WEST SUSSEX COUNTY COUNCIL CONSULTATION

TO:	Arun District Council FAO: Simon Davis
FROM:	Alison Meeus Highways, WSCC
DATE:	01/08/2018
LOCATION:	BR-324-17 283 Chichester Road, Bognor Regis, PO21 5AH
SUBJECT:	Residential development of 12 dwellings, access road, and car parking. Additional Information provided:- 1) Technical Note including Stage 1 Road Safety Audit
DATE OF SITE VISIT:	n/a
RECOMMENDATION:	☐ Advice ☐ Objection ☐ Modification ☒ No Objection ☐ More Information ☐ Refusal
S106 CONTRIBUTION TOTAL:	£ See below for breakdown.

Figure 3.1: Survey Area

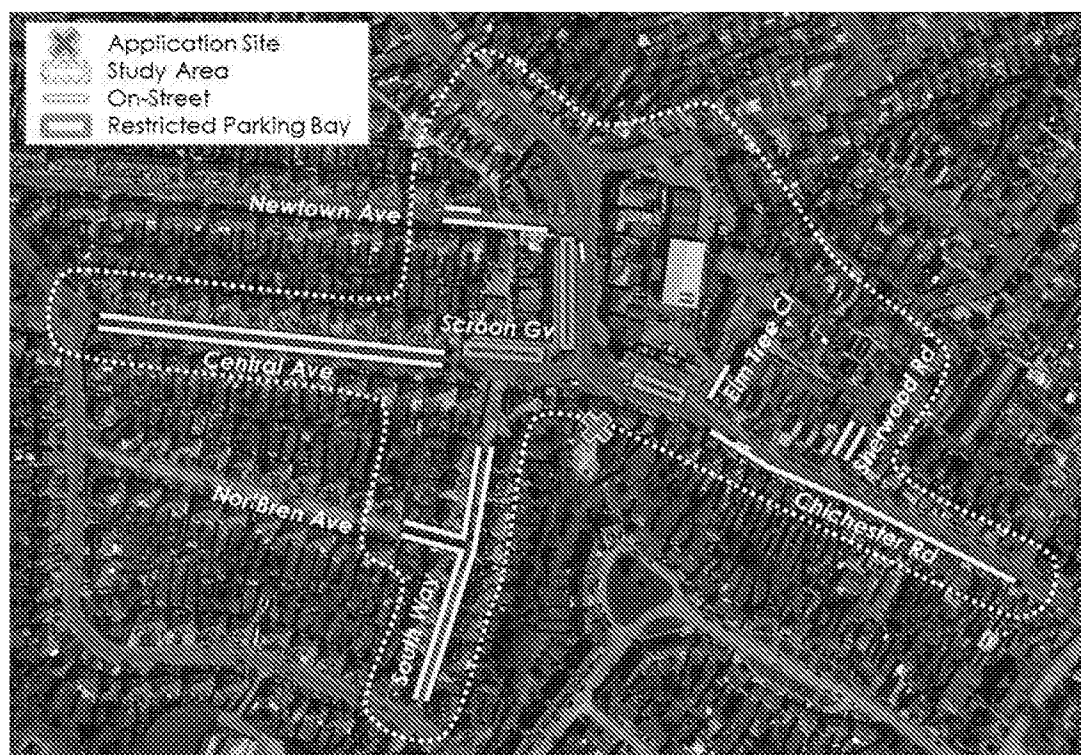
In order to assess the existing 'on-street' parking demand in the vicinity of the development an 'on-street' parking survey was undertaken using the Lambeth Methodology. This method is robust and a useful way of identifying the peak parking conditions, specifically identifying parking stress levels.

Although the site provides enough parking for the dwellings it was noticed there was a slight under provision for visitor parking. The survey results demonstrate there is sufficient parking capacity in the surrounding local network to accommodate an additional 55 cars. Although some roads were busier than others (i.e. Chichester road was at a 91% stress level) this is to be expected due to the shopping parade. However it is clear there would be space for visitors to park near-by, as such WSCC are satisfied with the proposal.
